SUBJECT: **BRES2301-0075**  
**BUILDING RESIDENTIAL**

Here are the results of all Inspections located at **1231 MURCHISONTOWN RD:**

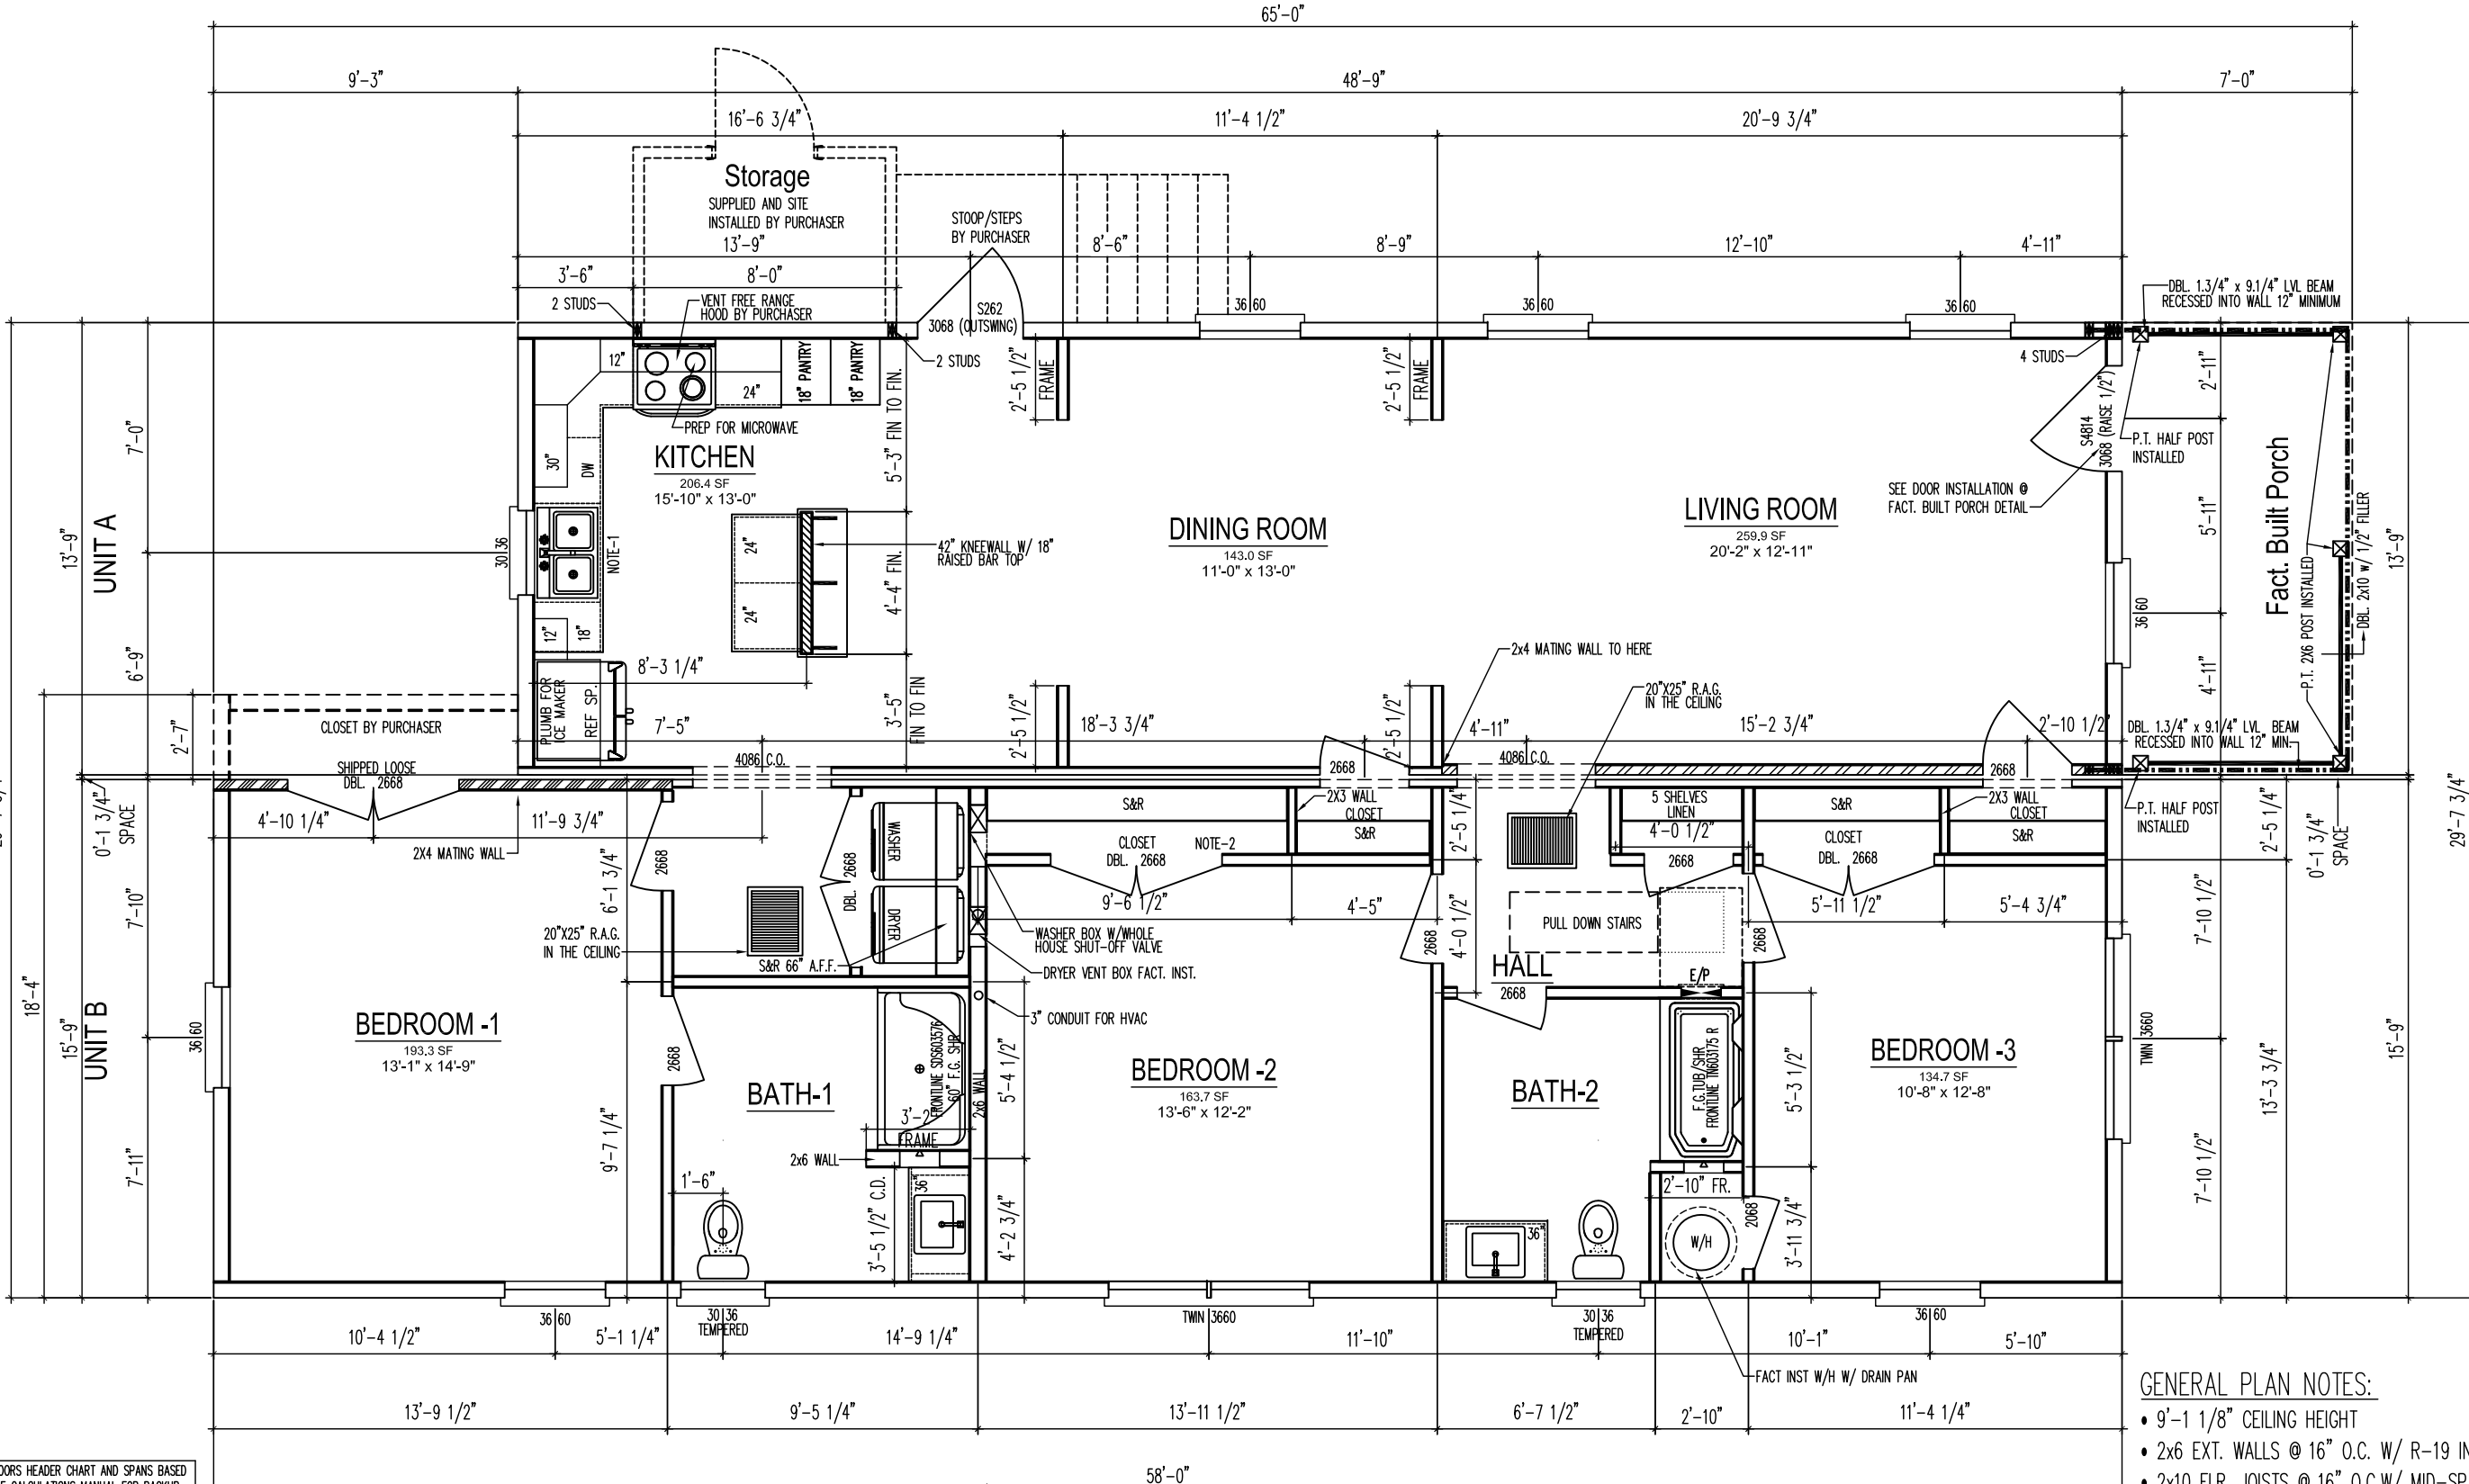
Inspection Type: FOUNDATION  
Scheduled Date/Time: 12/5/2024  
Completed Date/Time: 12/5/2024  
Inspector: Ricardo D Honrada  
Result: DISAPPROVED  
Remarks:  
Notes: Uncover the top of walls footings and pier's columns, to see the projections. Need anchor bolts ref. Code R403.1.6

**MATING WALL TENSION CONNECTION**

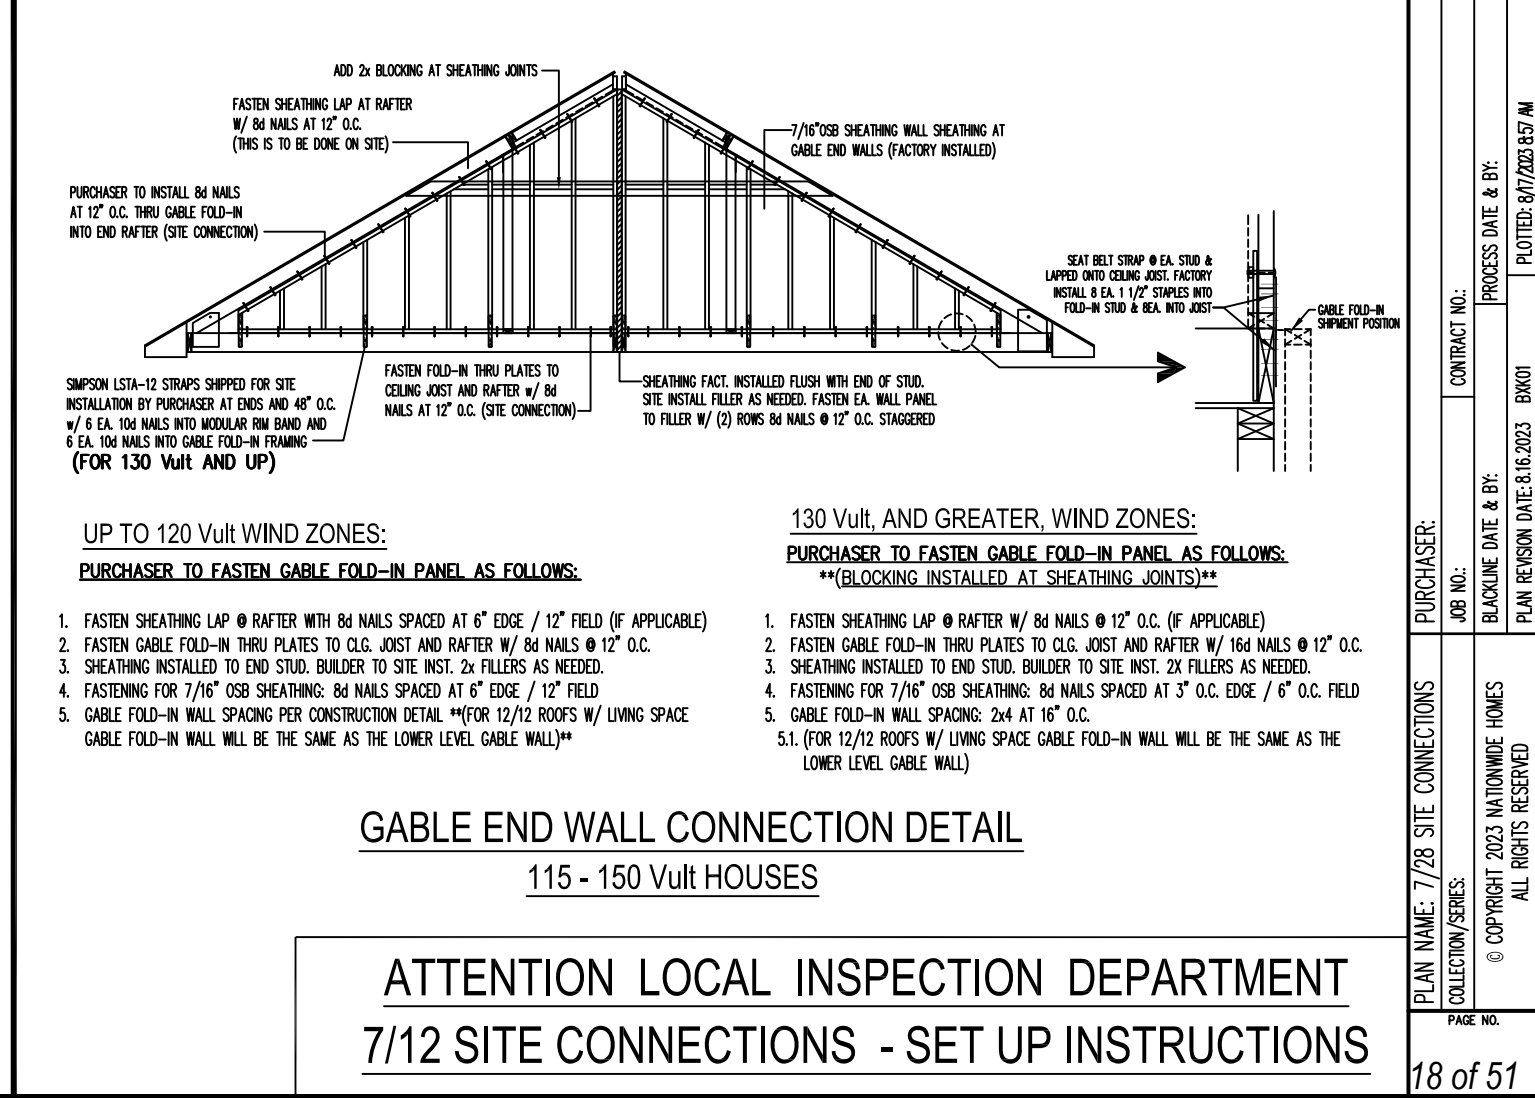
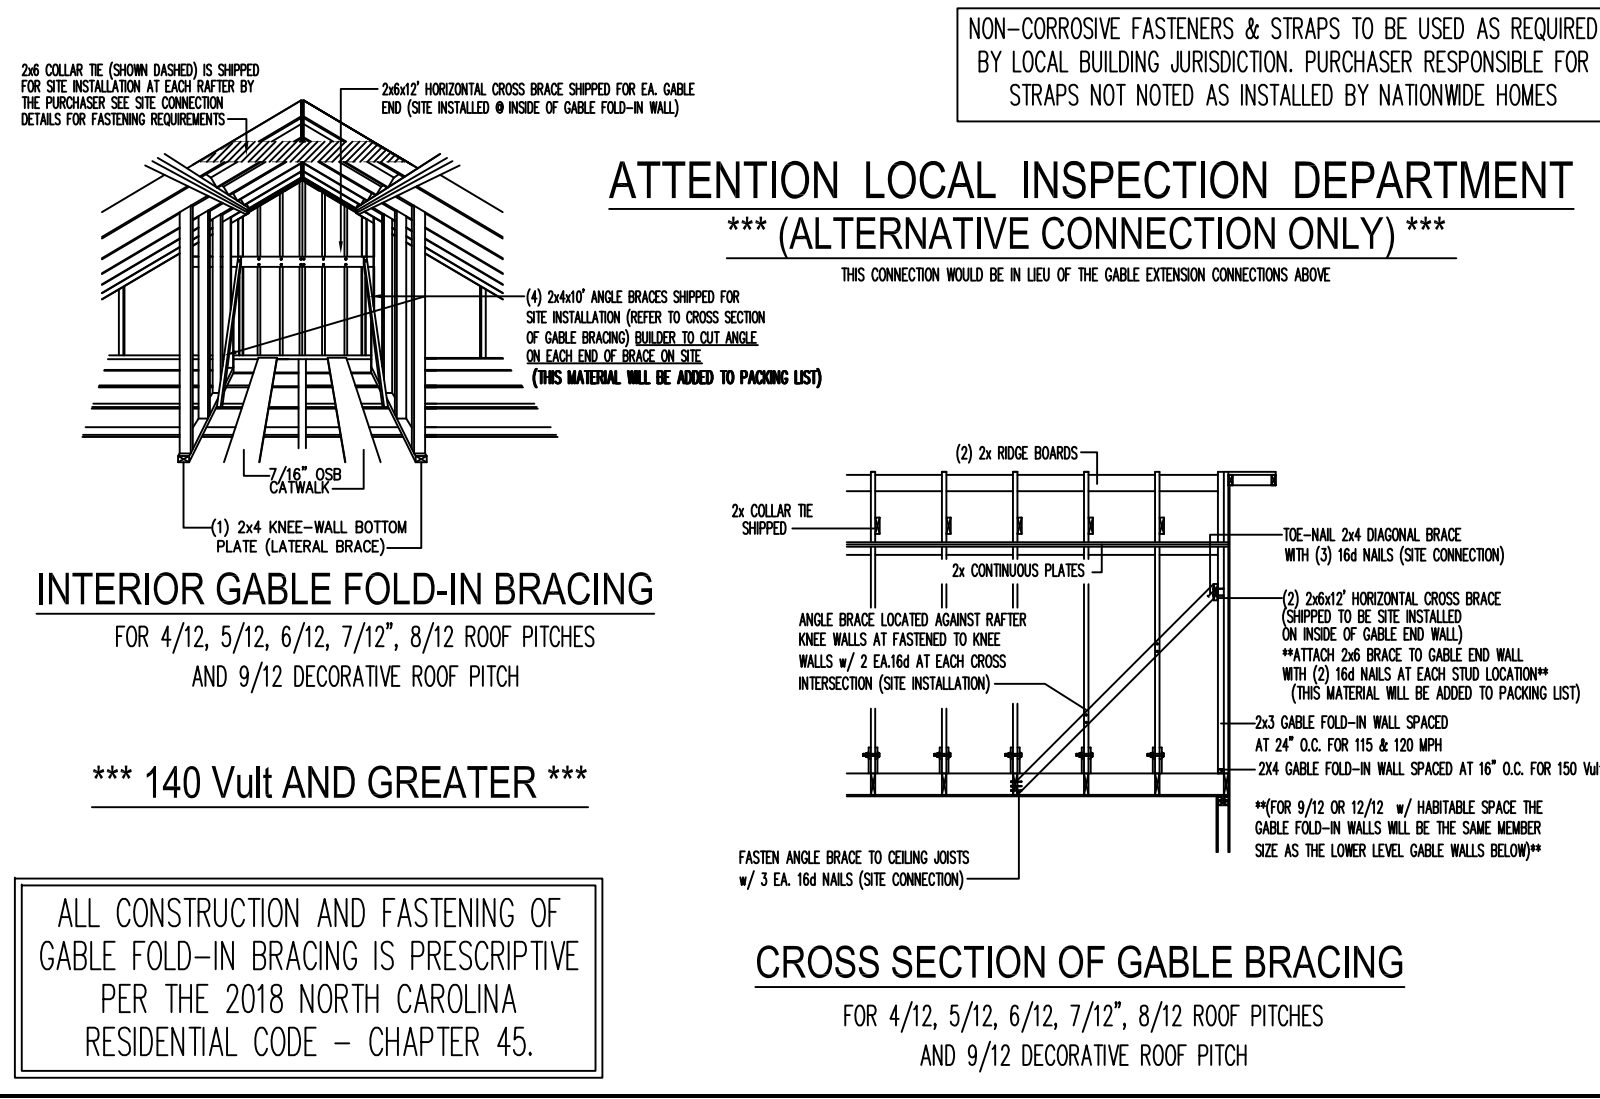
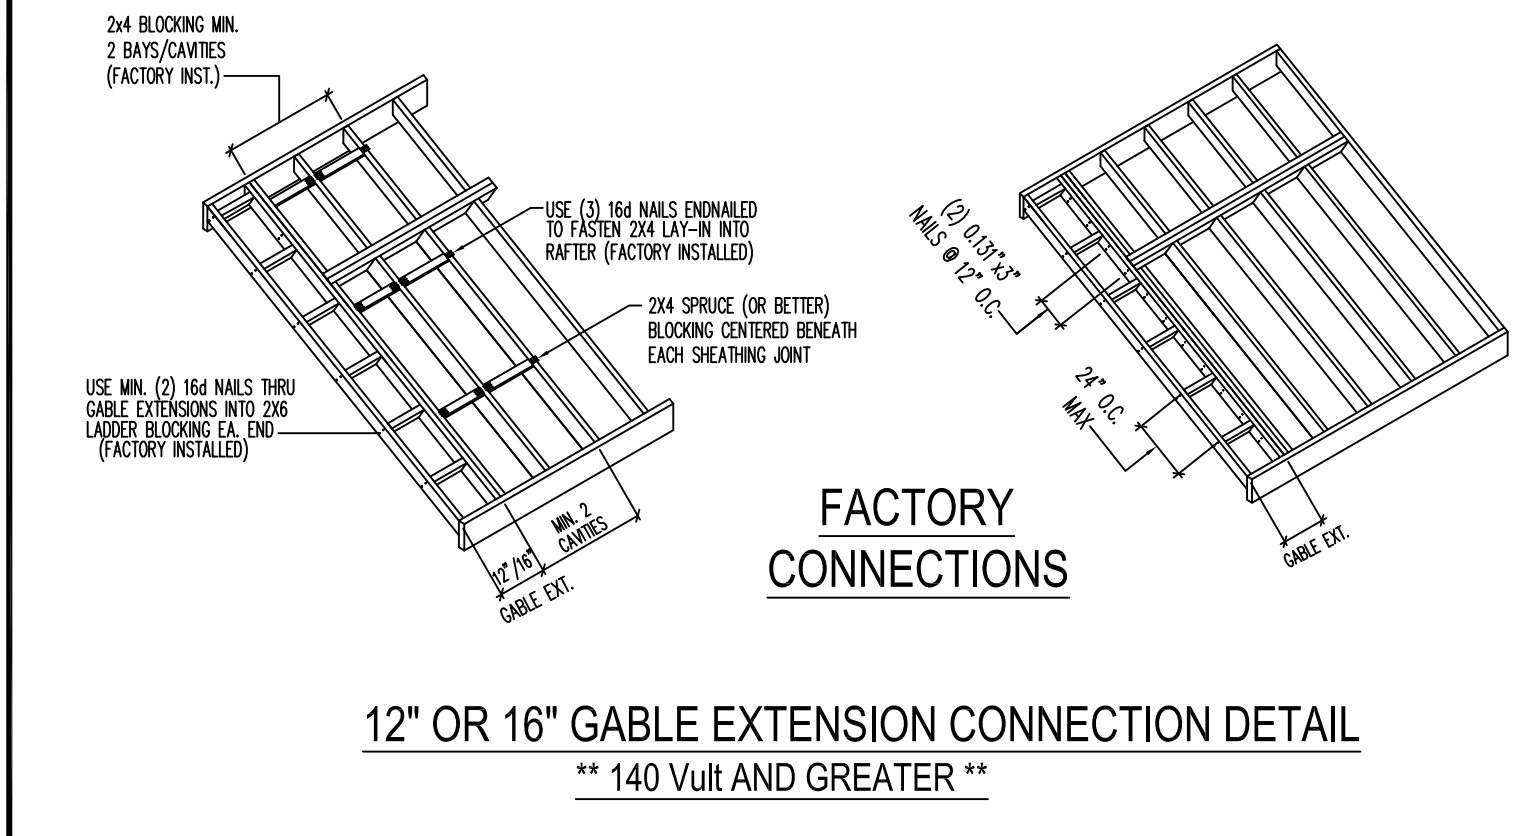
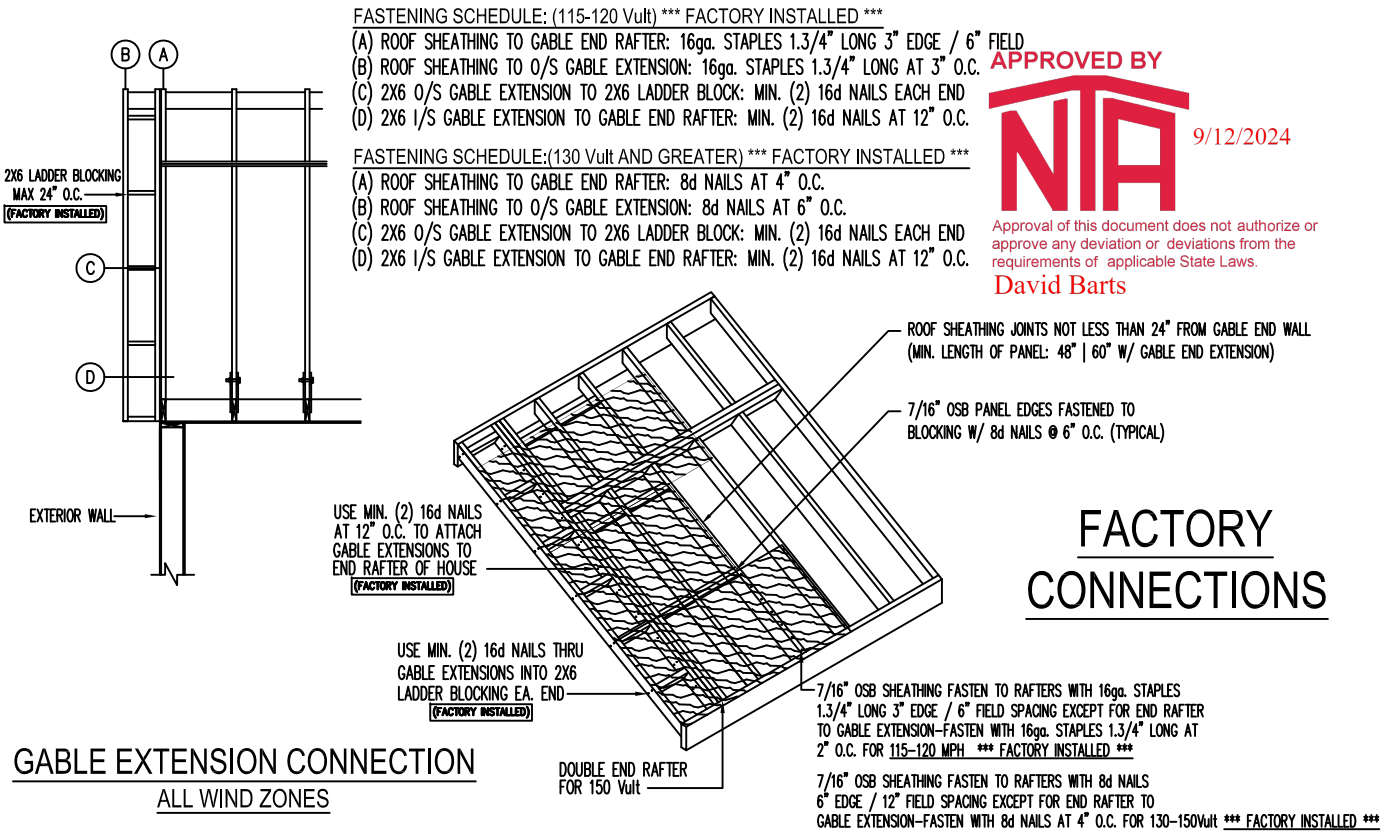
Inspection Type: MARRIAGE WALL  
Scheduled Date/Time: 3/18/2025  
Completed Date/Time: 3/18/2025  
Inspector: Ricardo D Honrada  
Result: DISAPPROVED  
Remarks:  
Notes: LOCK BOX 4760  
Need follow as per plan detail H metting wall tension connection. Need portable toilet.
